From: James Bonner <BONNER@shoalhaven.nsw.gov.au>
Sent: Thursday, 18 September 2014 4:36 PM
To: Robert A Byrne
Subject: FW: Vincentia District Town Centre Mod 6 reply to Planning and Environment
Importance: High

Council has reviewed the information supplied by TPG for Mod 6 of Part 3A 06_0025 for the Vincentia District Town Centre and provides the following comments:

1 ELEVATION
WEST ELEVATION - MOONA CREEK ROAD

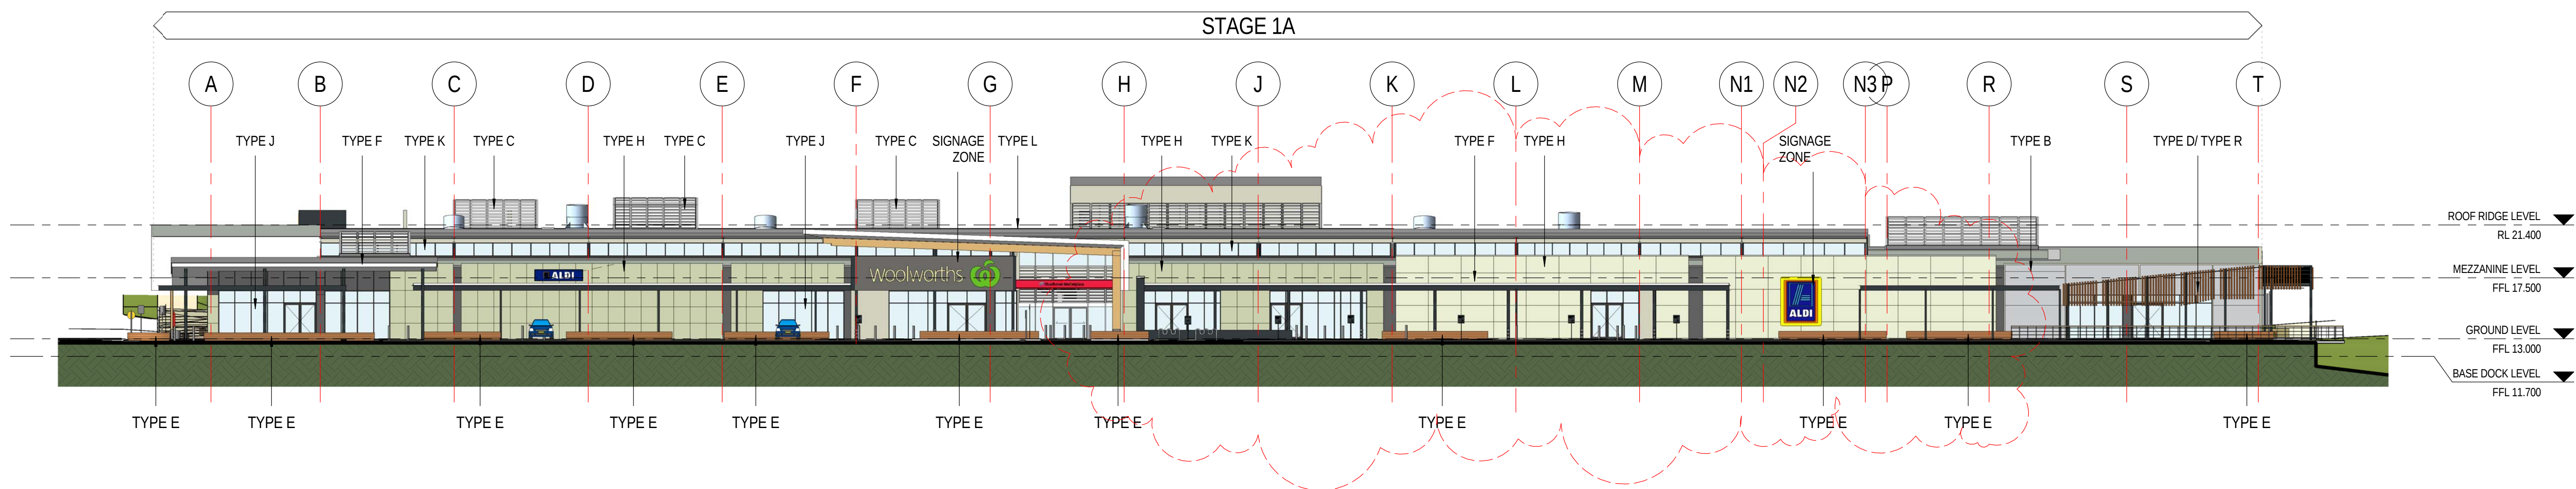
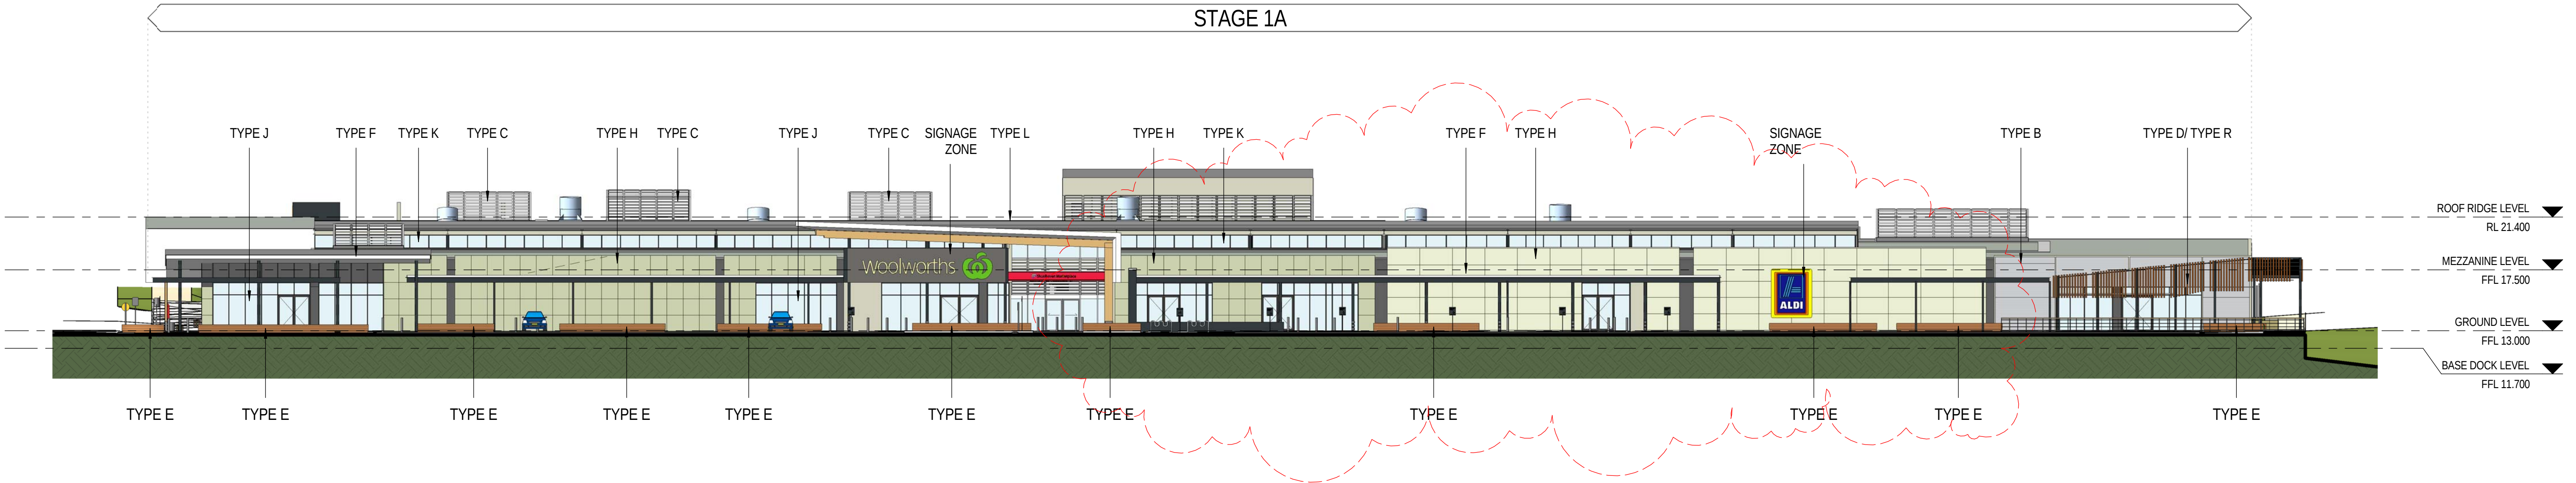
- Council has no particular objection to shops T.31 & T.32 being deferred to Stage 1b provided that suitable design treatment to improve the presentation of the building facing Moona Creek Road is provided until the shops are constructed as part of Stage 1b. This treatment could possibly including a number of measures such as enhanced landscaping, utilisation of different colours and types of material finish of the façade, possible replication of the proposed timber pylon treatment located at the entrance gateway.

- The same sort of treatment or attention is also suggested for the loading dock area.
- Stage 1b plan indicates the street trees planted as part of stage 1a will be located within the 25 angled car parking area on Moona Creek Road that were deferred from stage 1a.
